2 September 2019

Appendix A – Response to State and Local Government Agency Submissions

1.1 Department of Planning, Infrastructure and Environment

08 Public Domain materiality

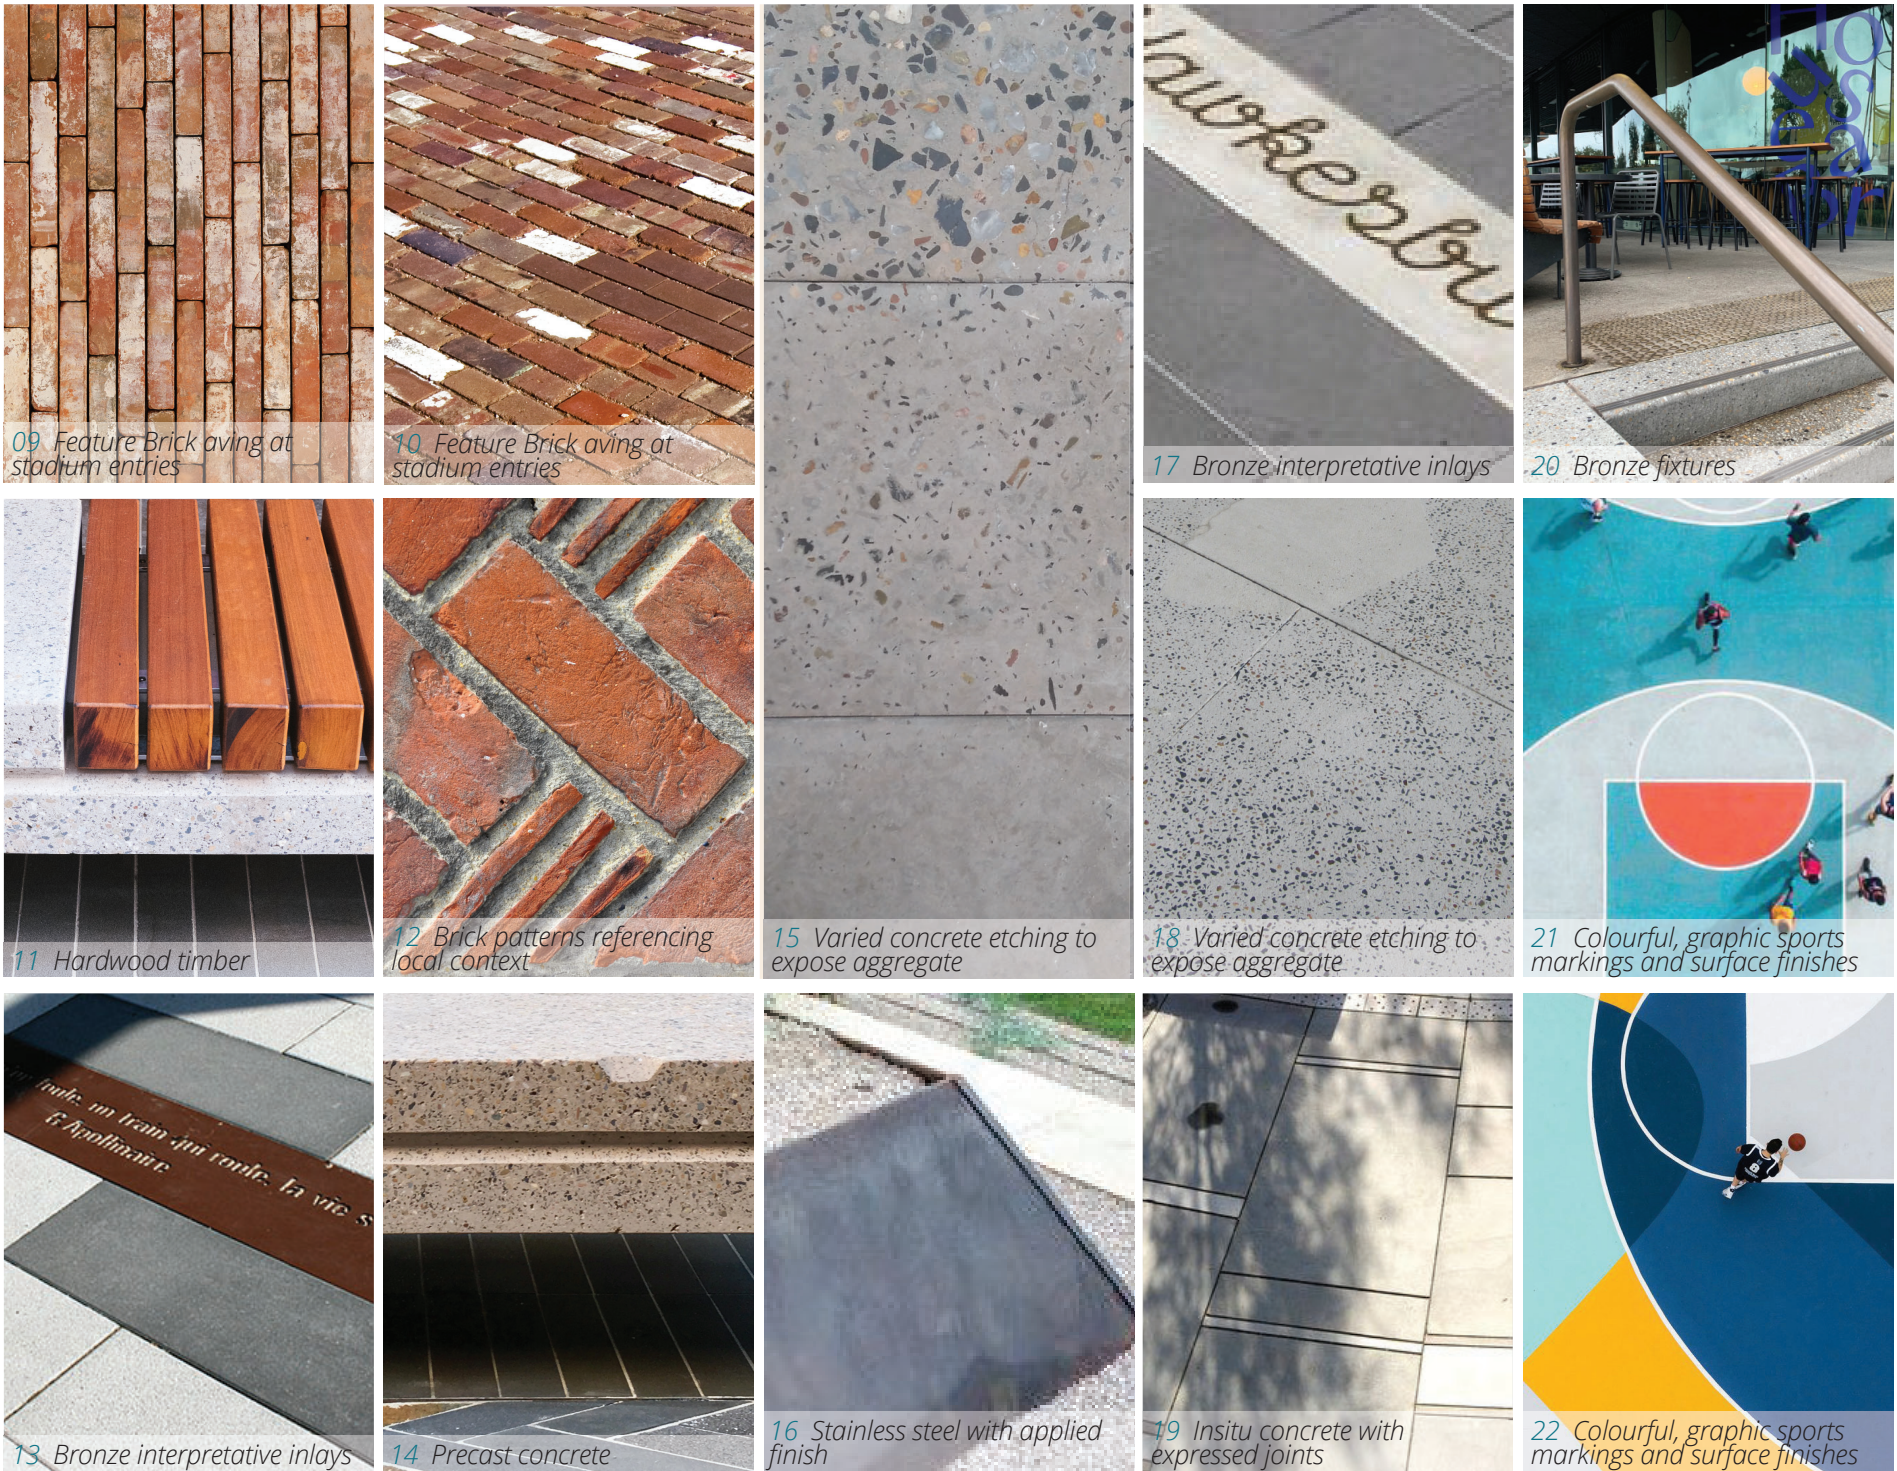
COS4	<p>Public Domain Materials</p> <p>The proposal involves the use of brick pavements as a “front door” materiality feature at the key entries and gathering spaces. From an accessibility perspective, the small brick pavers on such a large scale can be problematic and can lead to uneven surfaces, which are uncomfortable for people with injuries and can be difficult for people with wheelchairs and limited mobility. An alternative paving material must be considered for the primary entrances, including larger format pavers with less opportunity for heaving. Areas can still be distinguished by colour contrast and use of textured borders to ensure that the intent for feature materiality is still achieved.</p> <p>The proposal also provides integrated seating options in the public domain. To ascertain that people with disabilities can enjoy seating with equity that is safe, predictable and consistent, the seating should be designed in accordance with the performance standards outlined in Part 1.4 – Stairs and ramps of the Draft Guidelines in the following ways:</p> <ul style="list-style-type: none"> • Ensure that some integrated seating include back and arm rests to make seating more inclusive for the elderly; • Provide regularly recessed areas in integrated seating to enable wheelchair users and families with prams to sit together; 	<ul style="list-style-type: none"> • The use of brick pavers was informed by Council's street codes, the context of Paddington and to bring human scale to the expansive concourse. Aspect Studios confirm that brick pavers are only problematic when laid on sandstone substrate, and as such the proposed brick pavers are to be laid on concrete slab with mortar joints. Further, Aspect Studios has successfully used brick pavers in the public domain for a number of projects within the City of Sydney Council LGA, including Australian Technology Park, Kensington Street in Chippendale and Newcombe Street in Paddington. These areas are used as main public thoroughfares and would encounter a similar level of access by people with injuries and are mobility impaired, and have presented no significant hindrance to affected members of the public. Through detailing and collaboration with the project engineer, an even application of brick can be achieved. • The revised landscape and public domain plans at Appendix C incorporate seating (Type 1 in the documents) with backrests to provide more inclusive seating options in response to this submission. The placement and design of seating and other public domain areas has been considered with regard to wheelchair users, providing gaps and areas for wheelchairs to move and rest within existing seating areas.
